12SYDPLA-0009

25/6/2012

Re: Review of landscaping plans of North Penrith Stage 2A

THORNTON PARK CONCEPT PLAN

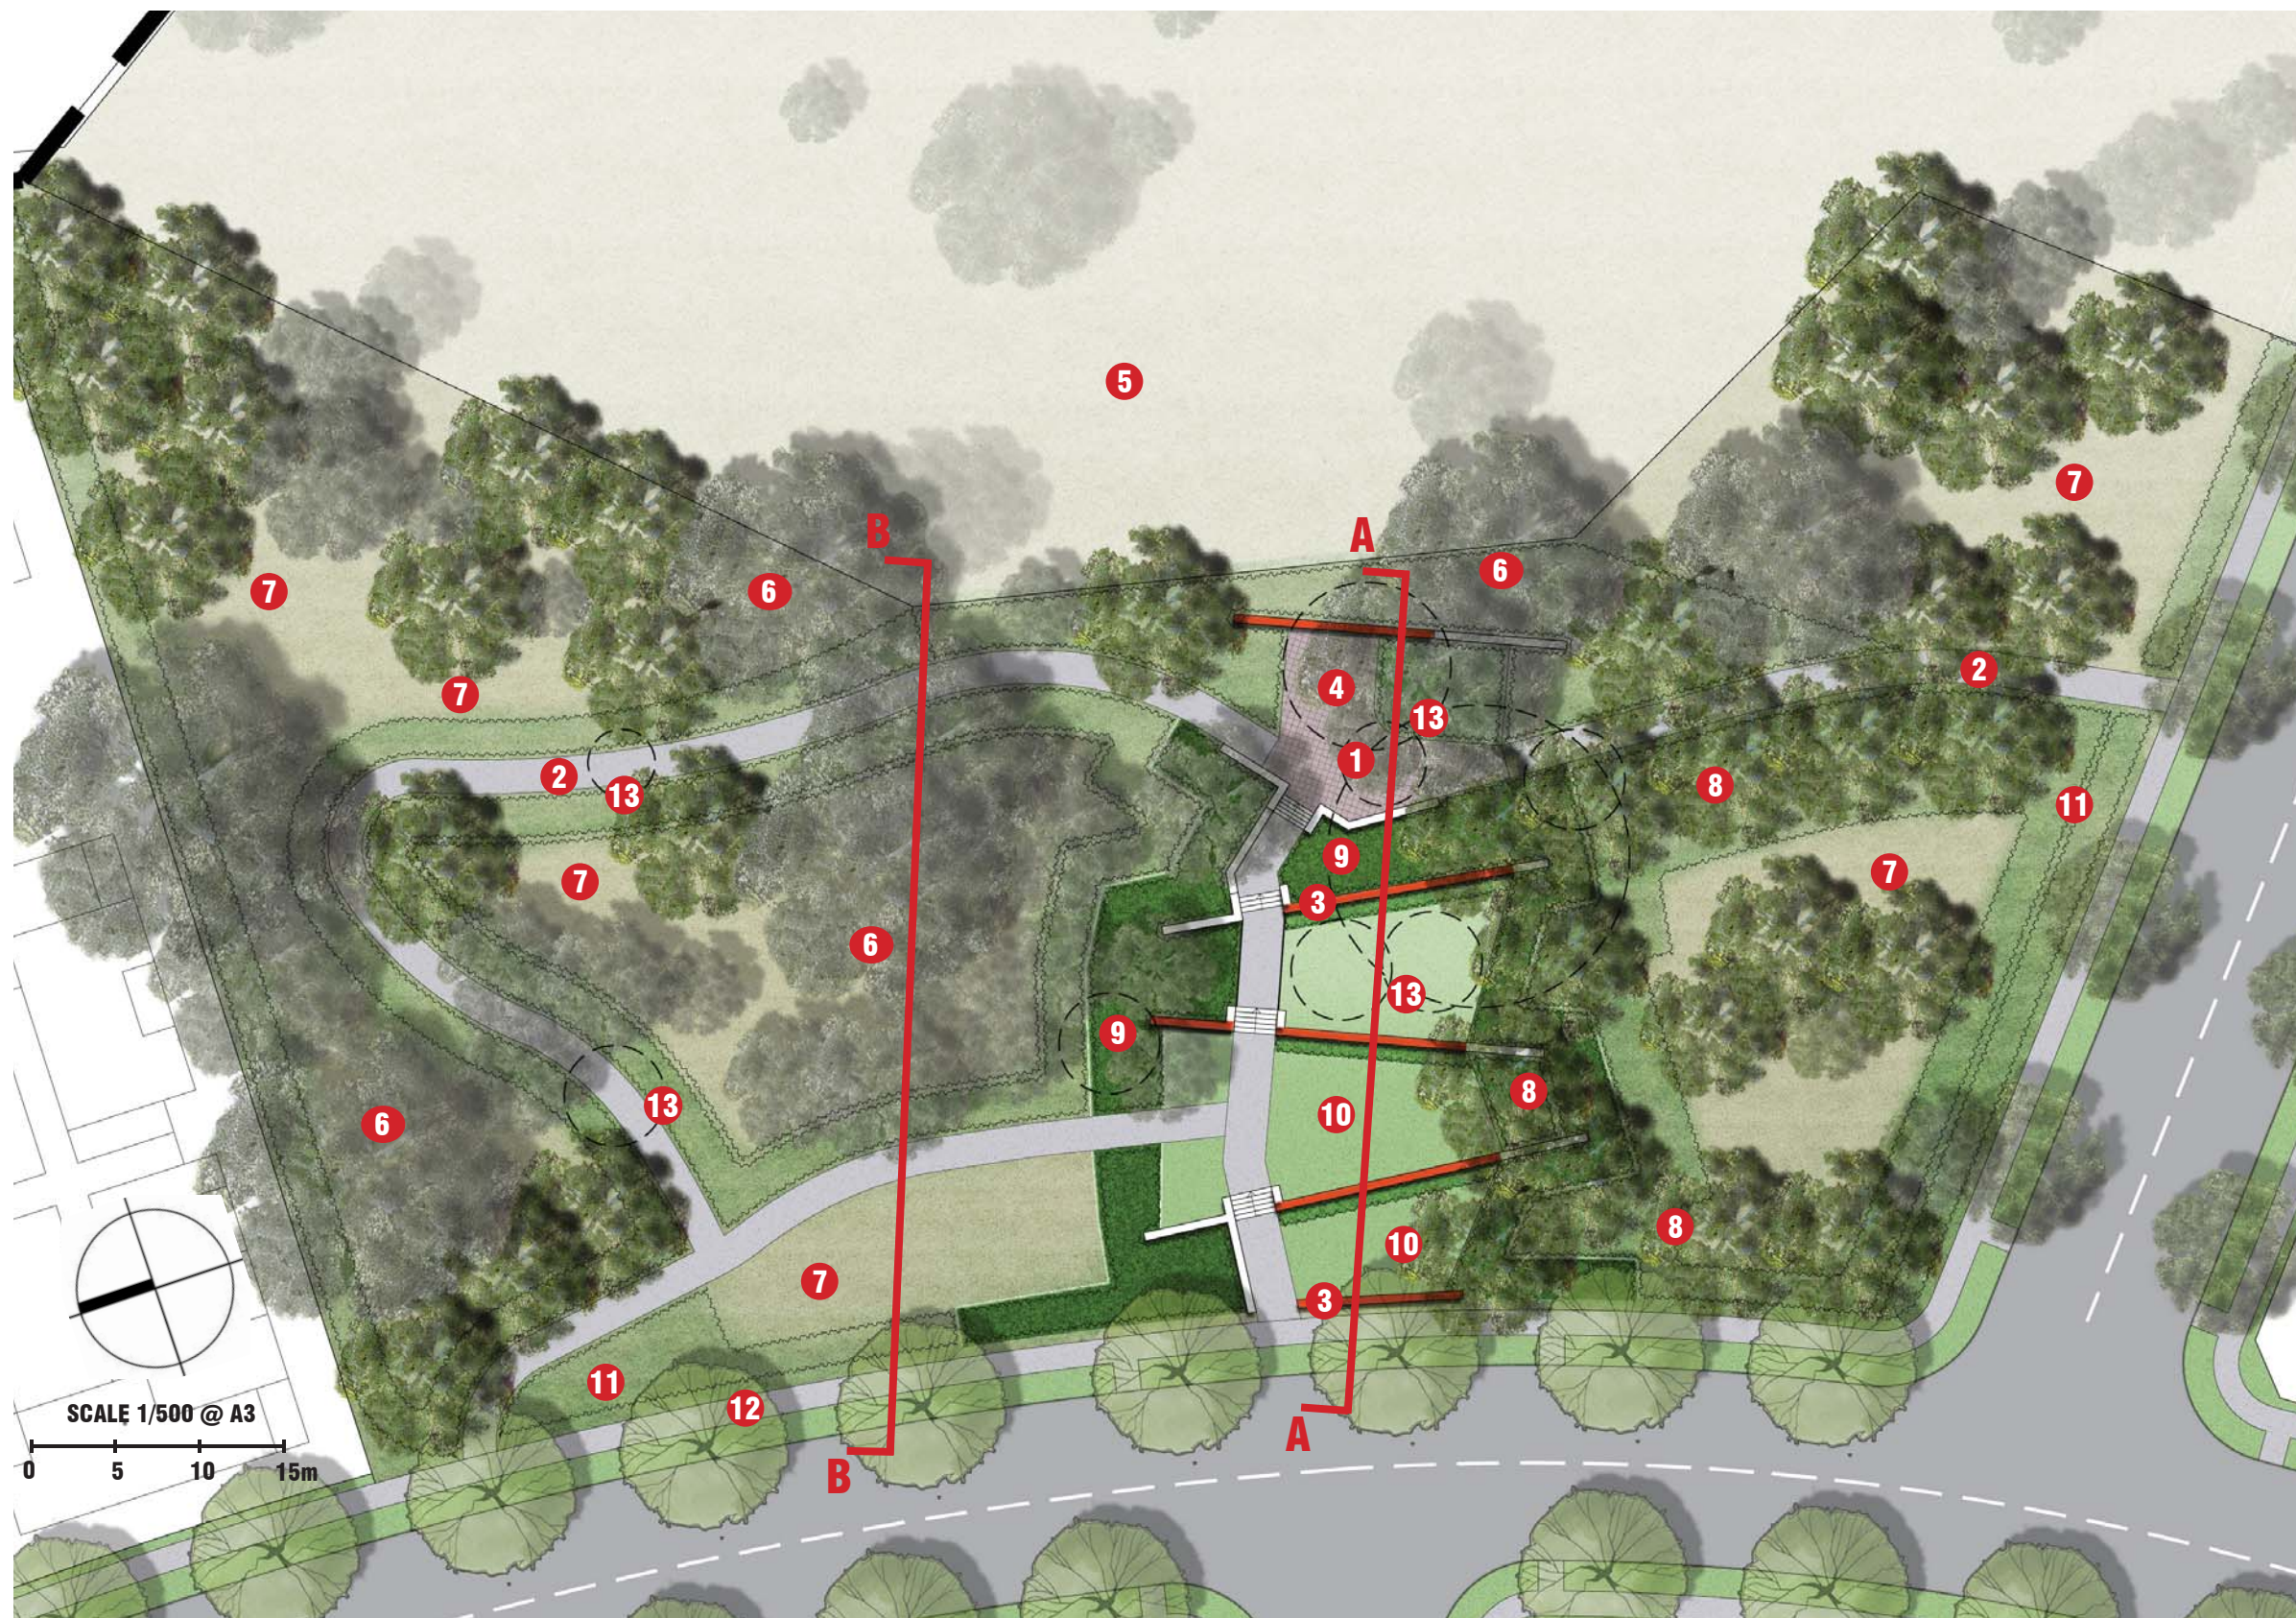
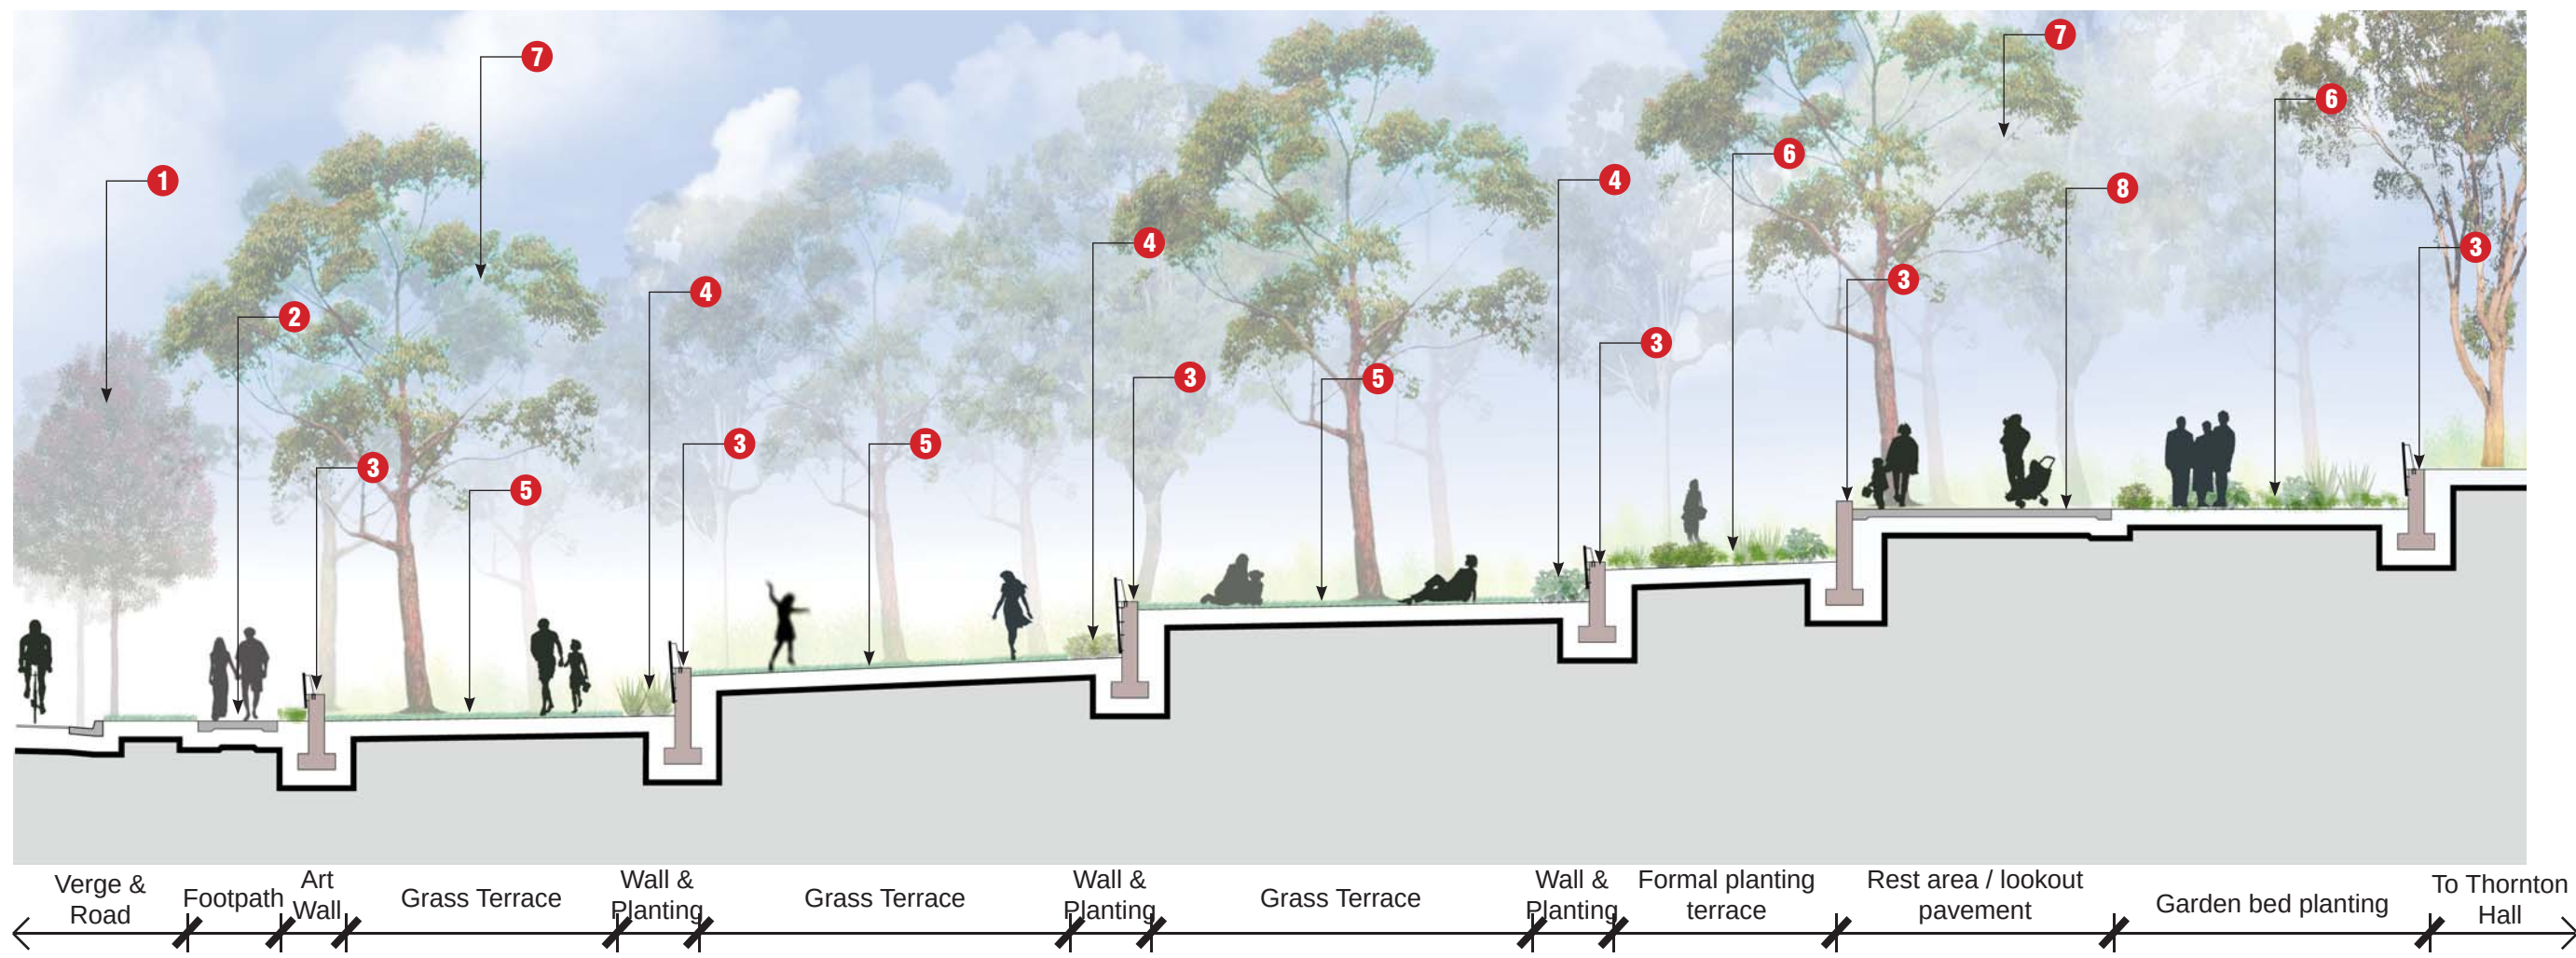
The Thornton Park Landscape Concept (Place Design 2012) is very similar to the plan included with the concept plan approval, and assessed in the Eco Logical Australia (2010) report. The Flora and Fauna Assessment Report identified that there would be the removal of trees and vegetation for the installation of walls, paths, and trees to create sightlines. The number of trees to be removed was not identified in Eco Logical Australia (2010). On review of Place Design (2012) it appears that a total of 9 trees for Cumberland Plain Woodland within the OS2 Park are proposed for removal, which is understood to be based on tree health assessments by Arboreport (2010, 2011), for installation of walls and paths, or to create sightlines. This is consistent with Eco Logical Australia (2010), which noted that *"The remnant trees of the CPW will mostly remain intact, subject to health and vigour assessments of a qualified Arborist"* (page 91, Eco Logical Australia 2010).

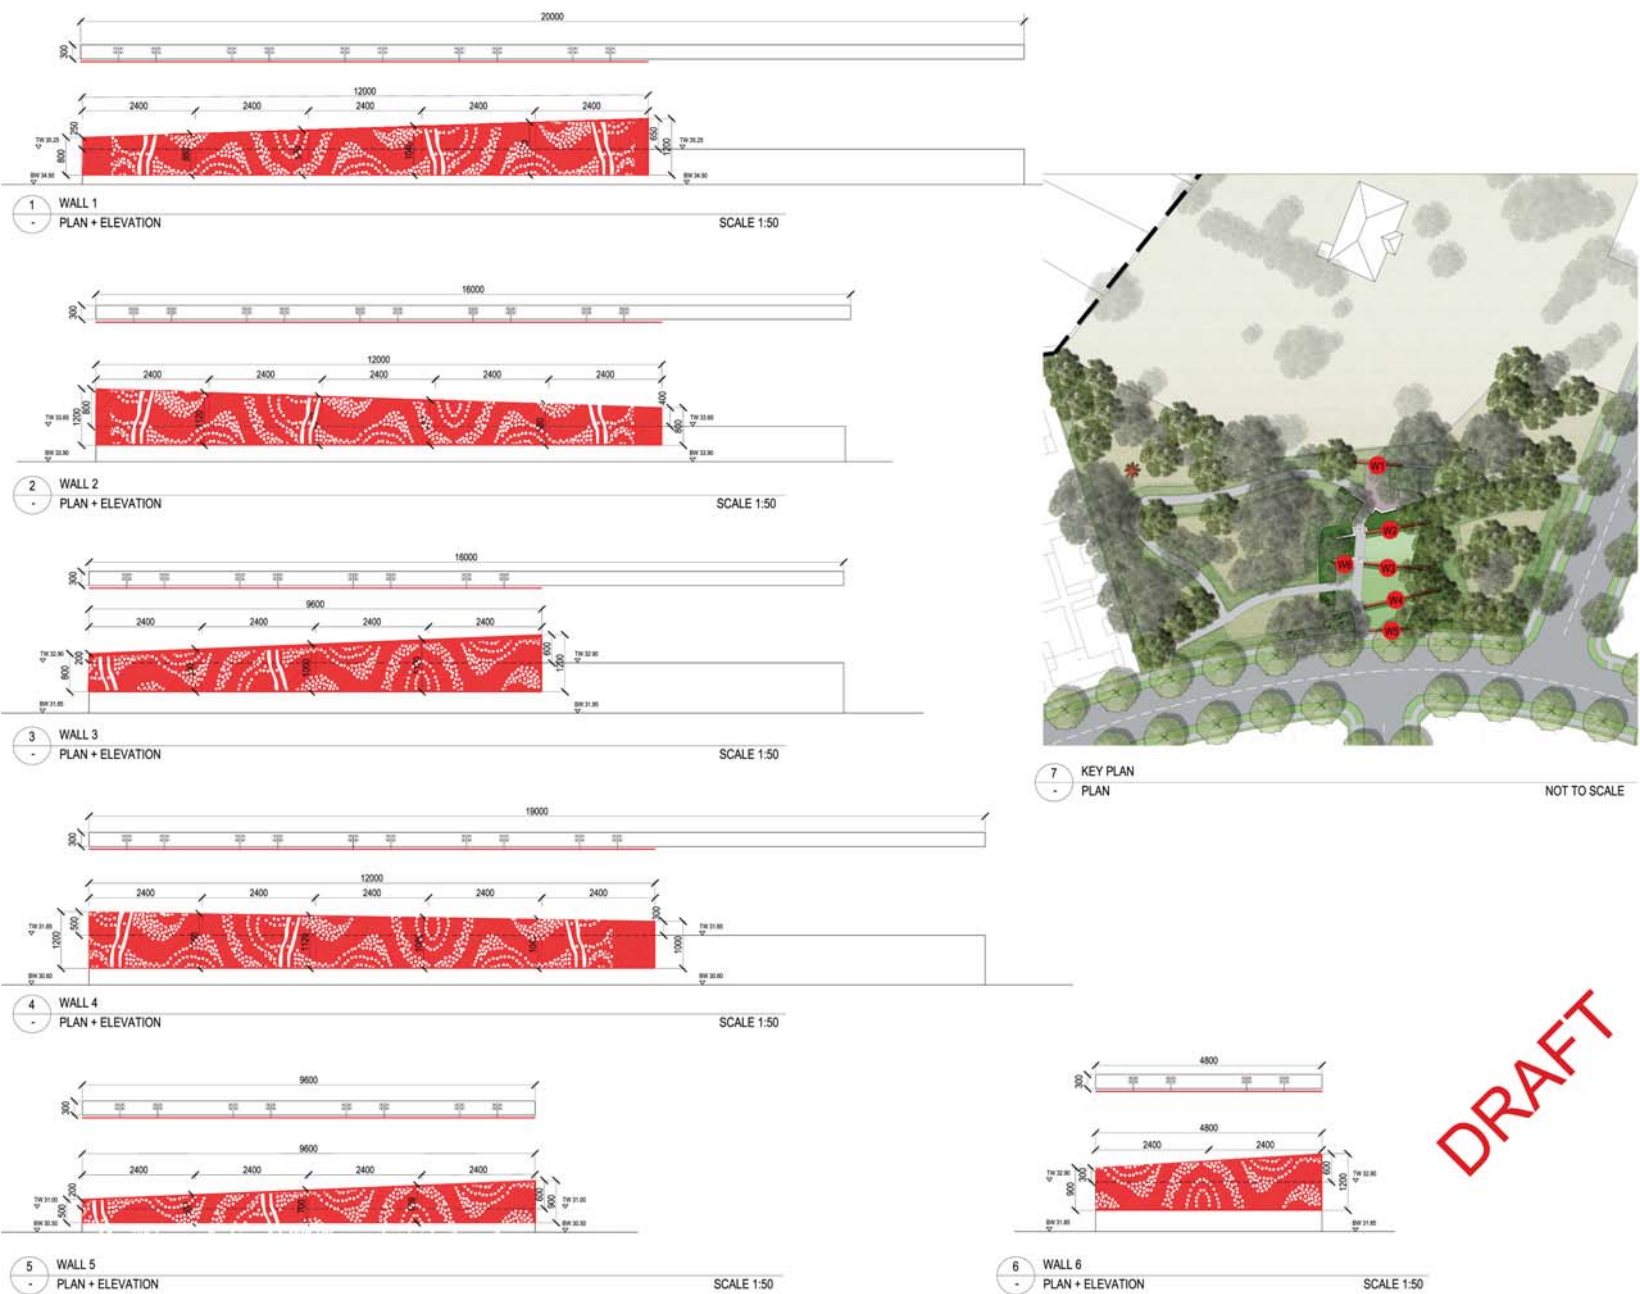
It is recommended that the cultivars proposed for the 'Cumberland Plain Woodland Revegetation' planting palette (Dianella 'Breeze', Lomandra 'Tanika', *Pennisetum alopecuroides* 'Nafray', and *Poa labillardieri* 'Eskdale') are switched to the 'open space' planting palette.
